218948

Appendix A – Response to Submissions

Extracts from Government agency and authority submissions and submissions from the general public received in relation to SSD 10342, and a response to each of these matters, has been provided in the sections below.

Drawing Status  
**Issue**

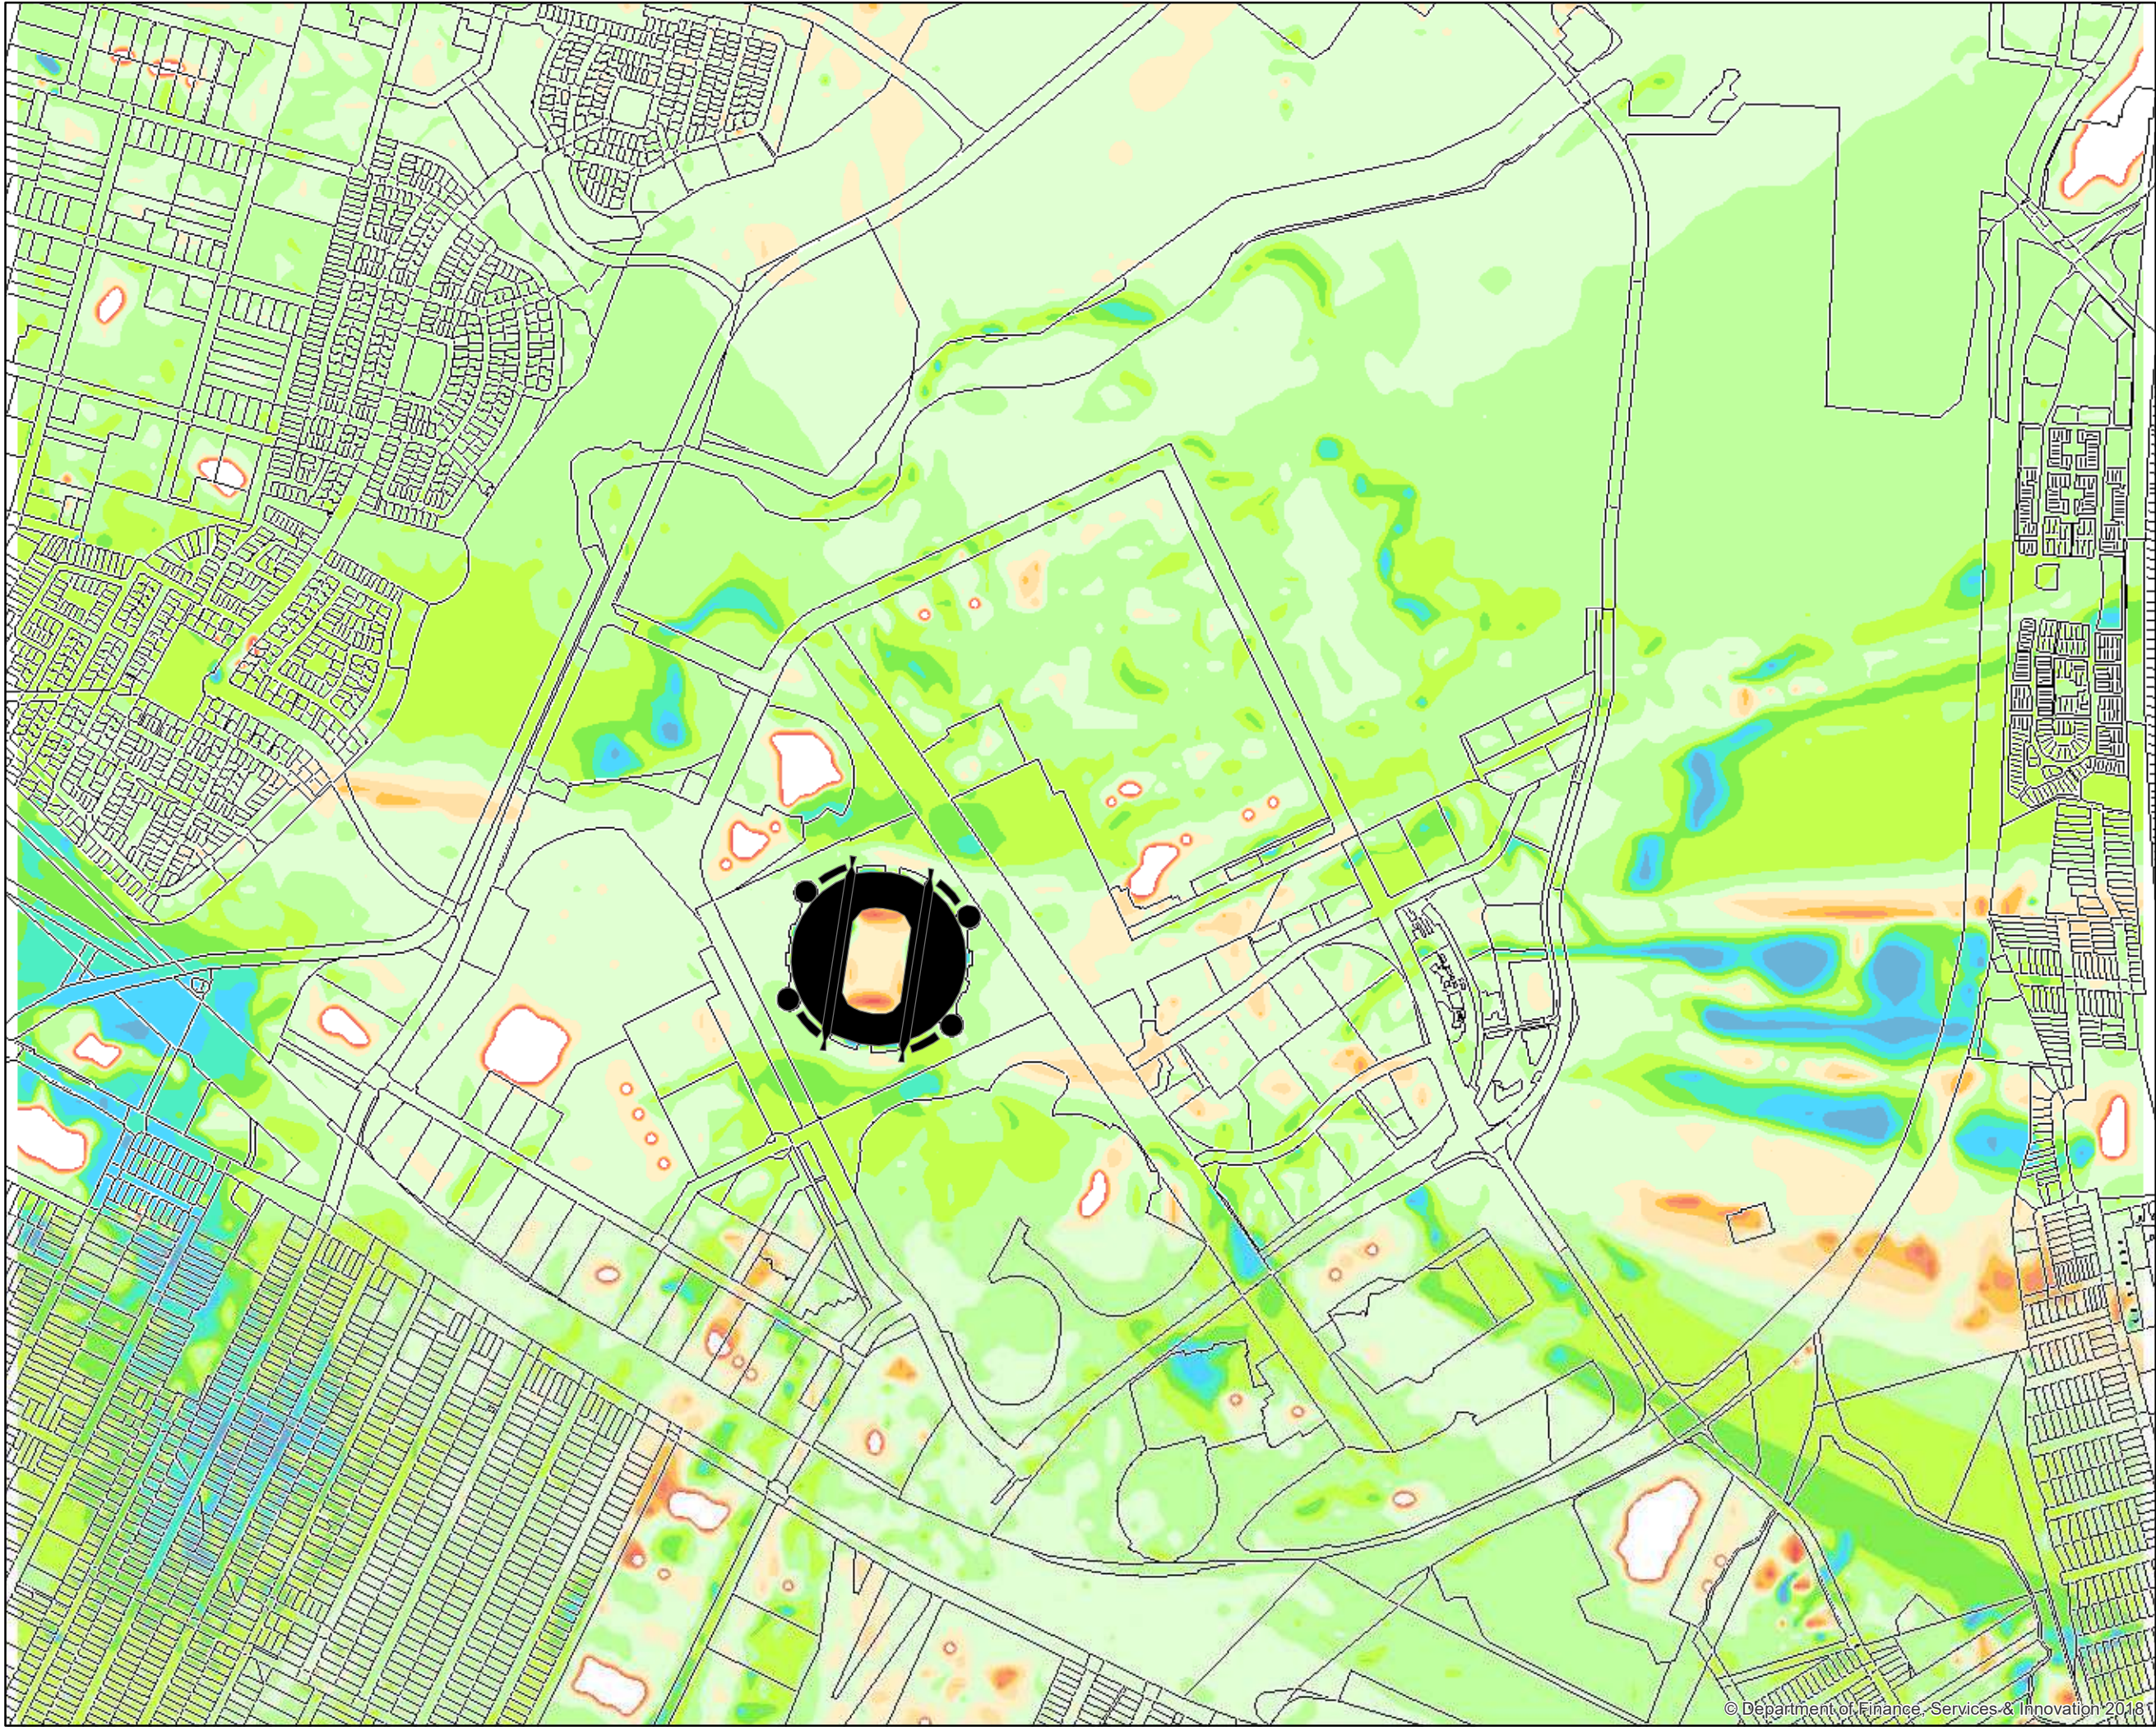
No.	Extract	Comment
EPA6	<p>Event noise management</p> <p>a) The Sydney Olympic Park Authority Act 2001 establishes the Sydney Olympic Park Authority (SOPA) as the Appropriate Regulatory Authority (ARA) for the stadium. The Act also includes a noise limit for events as the maximum permissible noise level from event noise of $L_{10,15min}$ 85 dB(A) at the nearest residential façade. The Noise Report has only presented a change in noise level in $L_{eq,15min}$. The EPA notes that the proposed modifications are generally minor in nature with regard to noise emissions. The Noise Report presents a comparative noise assessment for operational noise from events at the stadium. The predicted difference in noise levels presented in the report is relatively minor. The assessment does not present predicted noise as an absolute noise level and therefore the noise level potentially experienced by receivers adjacent to the stadium is not included in the report. This means that the footprint of noise impacts is not defined in the report and, as a result, an analysis of measures which could be implemented to reduce the noise footprint of the stadium is not able to be undertaken.</p>	<p>Section 4 of the revised Noise and Vibration Impact Assessment at Appendix C of this Response to Submissions assesses the proposal against the SOPA Act 2001 noise limits. Receivers which existed at the time the Act was implemented have been assessed to $L_{10,15min}$ 85 dB(A) at the nearest residential façade. Results for both concert and sporting events have been assessed, with three typical concert stage configurations modelled. Predicted levels at receivers which have been constructed since the Act was brought in have also been presented for reference, and noise contours generated in Appendix E.</p> <p>Results show noise levels from both the existing ANZ Stadium and the proposed Stadium Australia comply with SOPA Act 2001 noise limits.</p> <p>The footprints of event noise impacts are also presented in event noise contours that are included at Appendix C.</p>
